Ribble Valley Borough Council
Council Offices
Church Walk,
Clitheroe
Lancashire
BB7 2RA

Phone: 0300 123 6780
Email: developeras@lancashire.gov.uk
Your ref: 3/2026/0240
Our ref: 3/2026/0240/HDC/KW
Date: 02 June 2026

Location: South Lodge Mitton Road Whalley BB7 9JN
Proposal: Proposed extension of the residential curtilage, demolitions to allow the construction of a two-storey side extension and single-storey rear extension including an attached garage with associated alterations.
Grid Ref: 372566,436901

A2.2

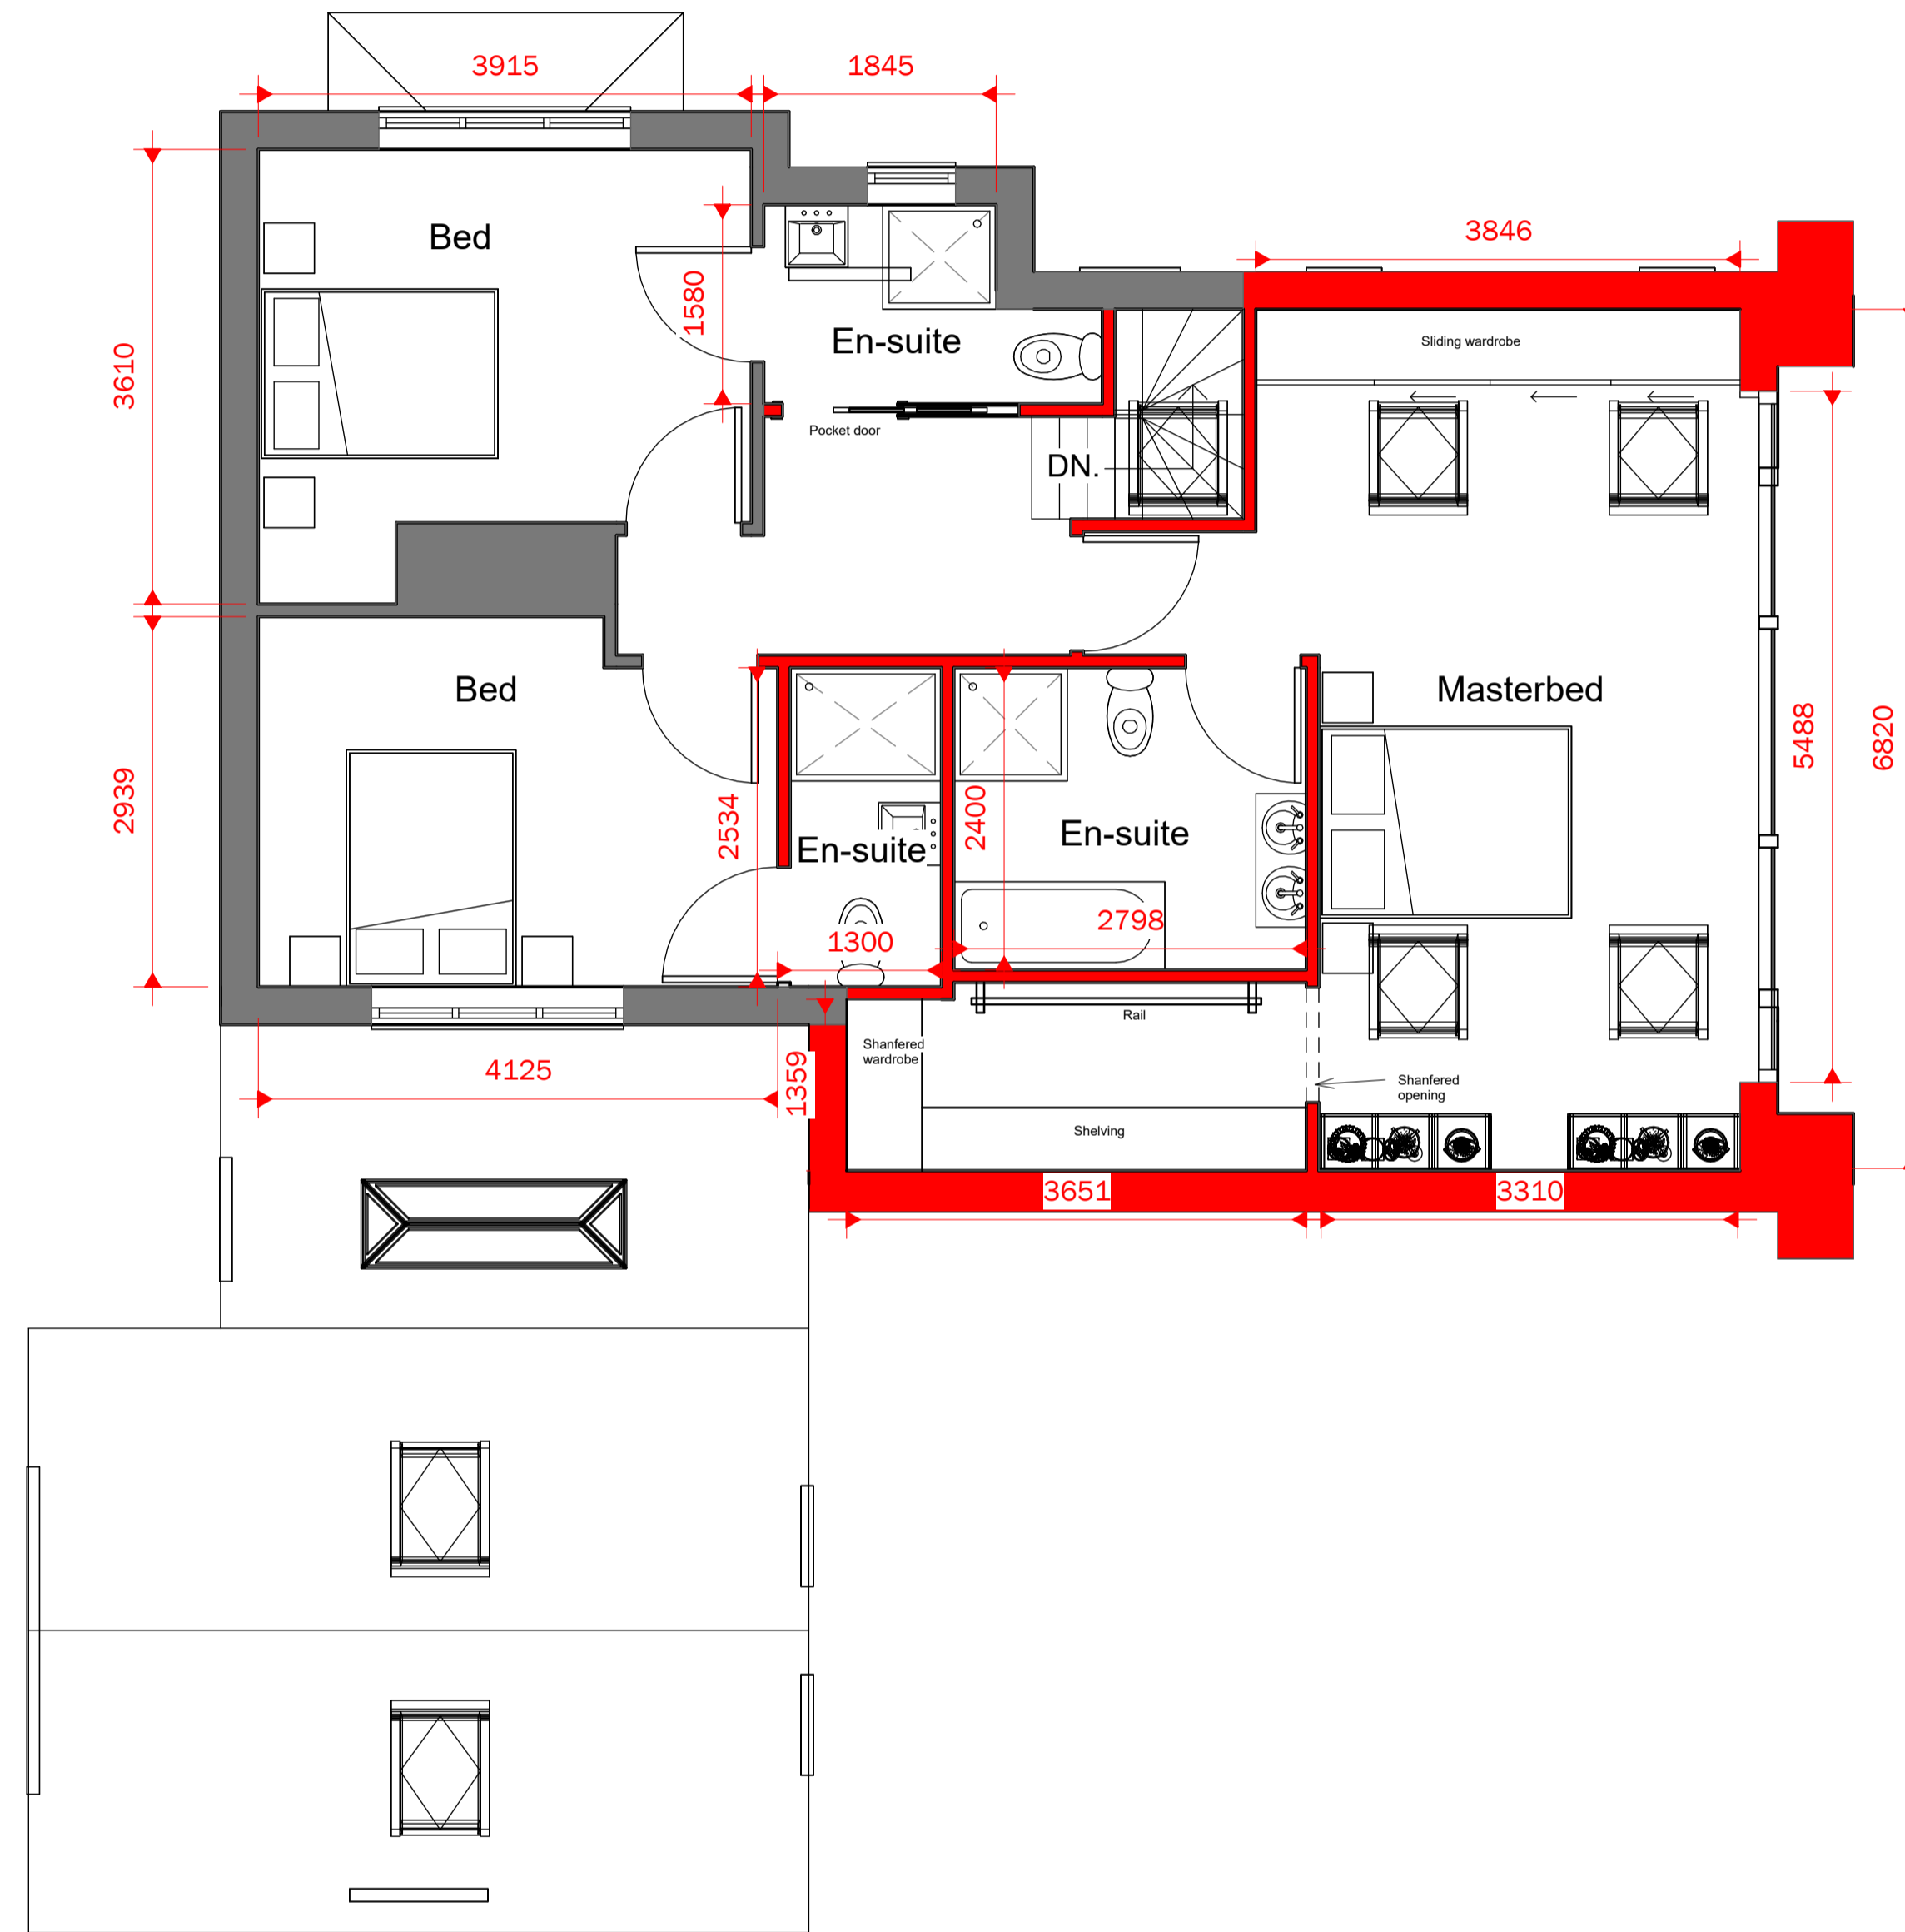
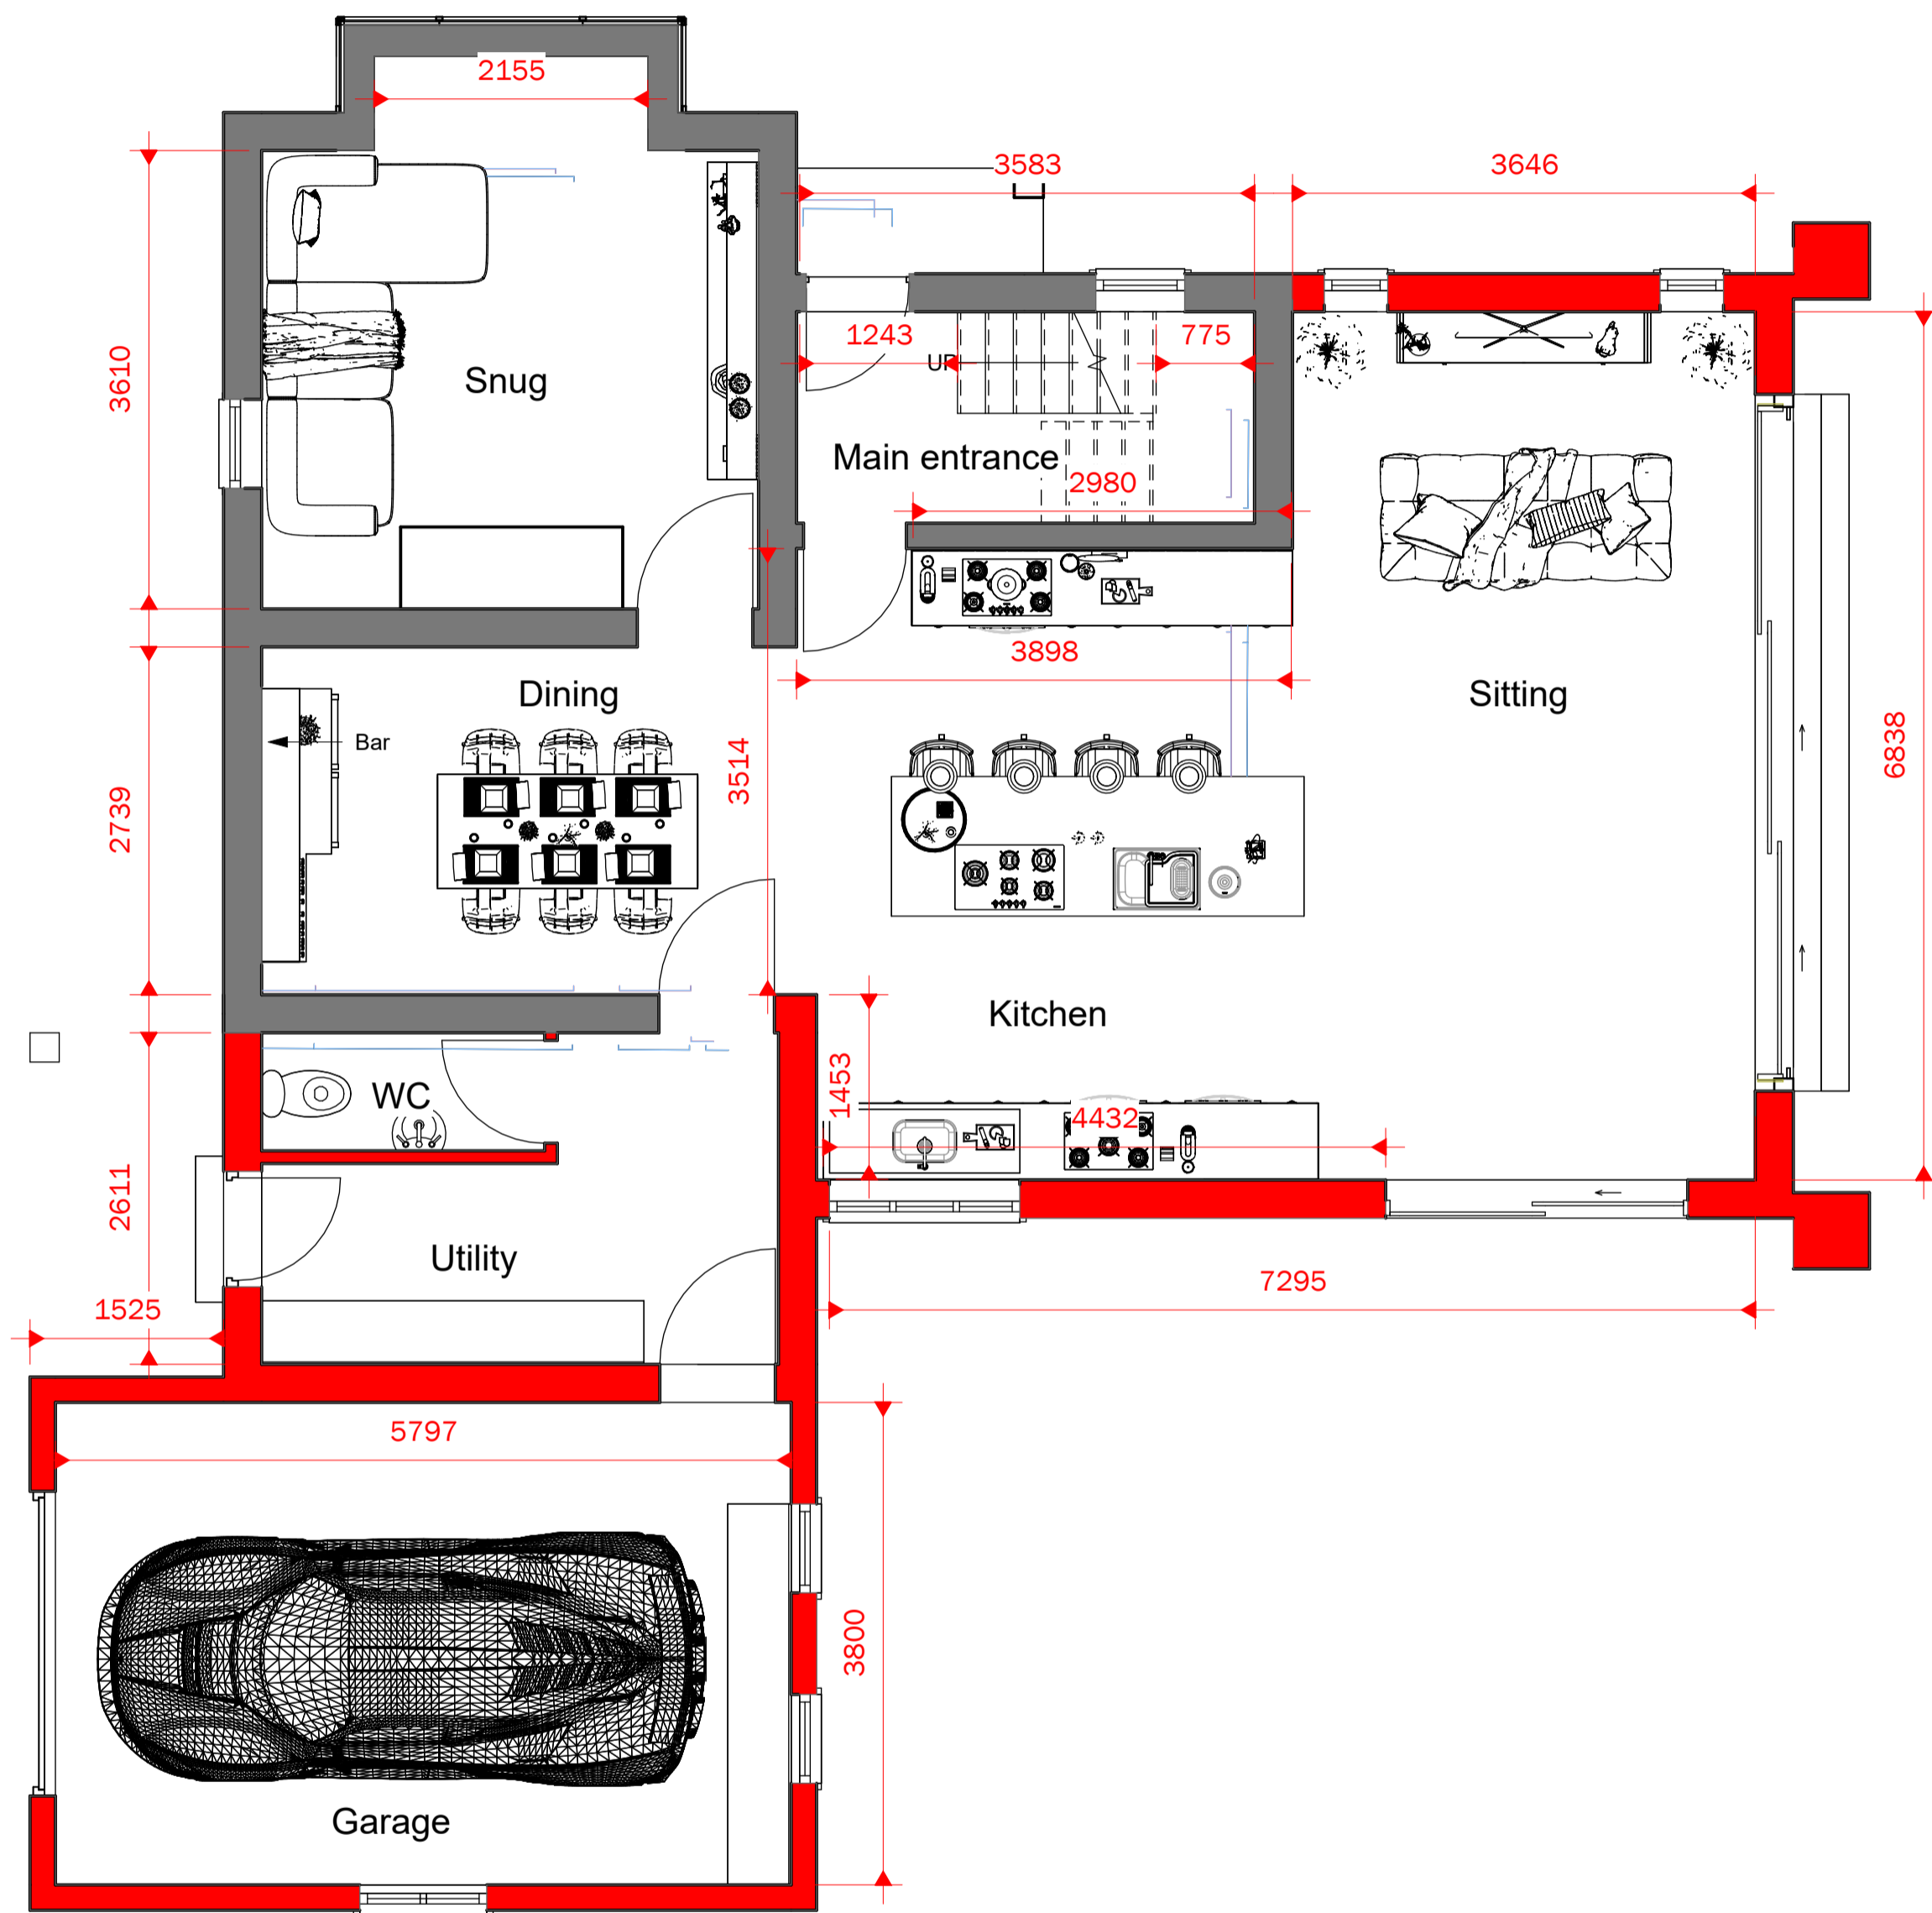
The LHA also reviewed drawing A2.2 titled proposed floor plans and noted that the proposed garage does not meet the LHA recommended minimum internal dimensions for a single garage size which is 6m in length and 3m wide. The recommended distance of 6m is based on the length of a large family car (Ford Mondeo Estate 4.58m long), clearance at the rear of the car (200mm), overhang of the garage door (600mm) and room to stand in front of the car and open/close the garage door (600mm). Where garages are smaller than the recommended minimum internal dimension of 6 x 3m they should not be counted as a parking space. In this case the recommended parking provisions for the dwelling size can be accommodated within the driveway.
